Your Ref: OWPC18406
Our Ref: AB/39/18/PL
Please ask for:
Tim Bloomfield

25th May 2018

Erection of 3 No. 2 bedroom dwellings with associated parking & landscape.
Land adjacent to 30 Ellis Close Arundel

Project & Drawing title					
location plan & proposed site plan / proposed section					
Drawn	Date	Checked	Date	Scale at A1	
tgm	04/10/16	rks	04/10/16	1:1250 1:200	
Job N°:	16/021	Drawing N°:	010	Rev.	P2
Status	PLANNING

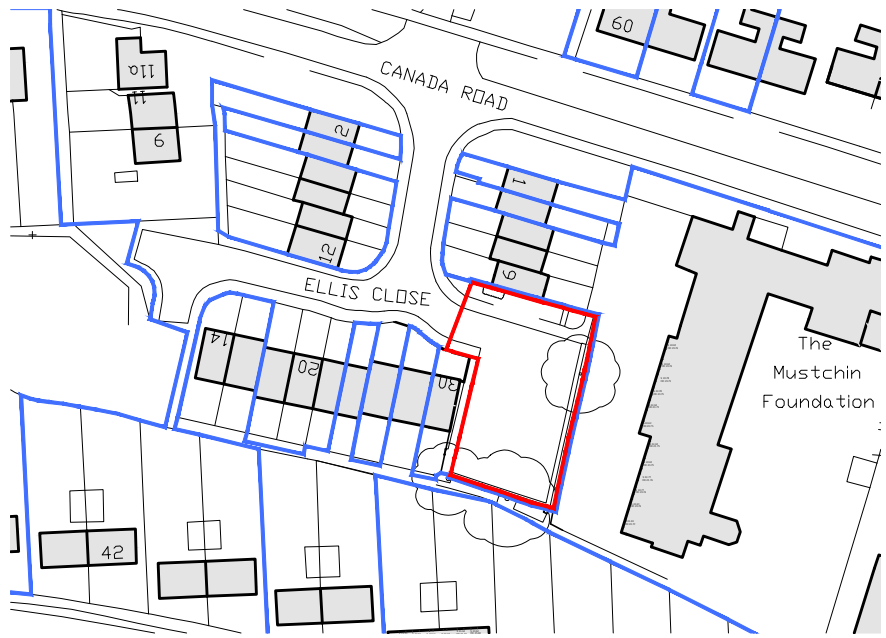
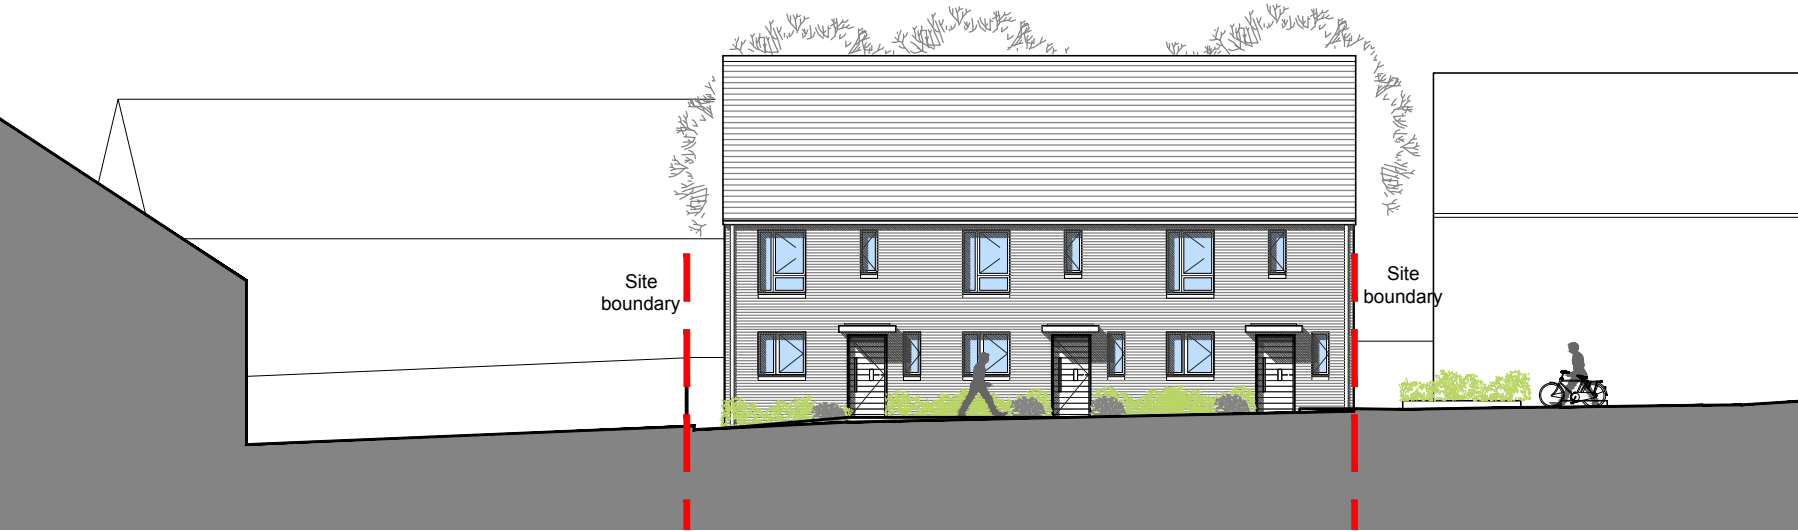
The Committee had no objection to the proposed social housing but regretted that the design had failed to acknowledge that the strip of frontage garden could have easily been incorporated to provide additional living space within dwellings which appear to be very limited in size.
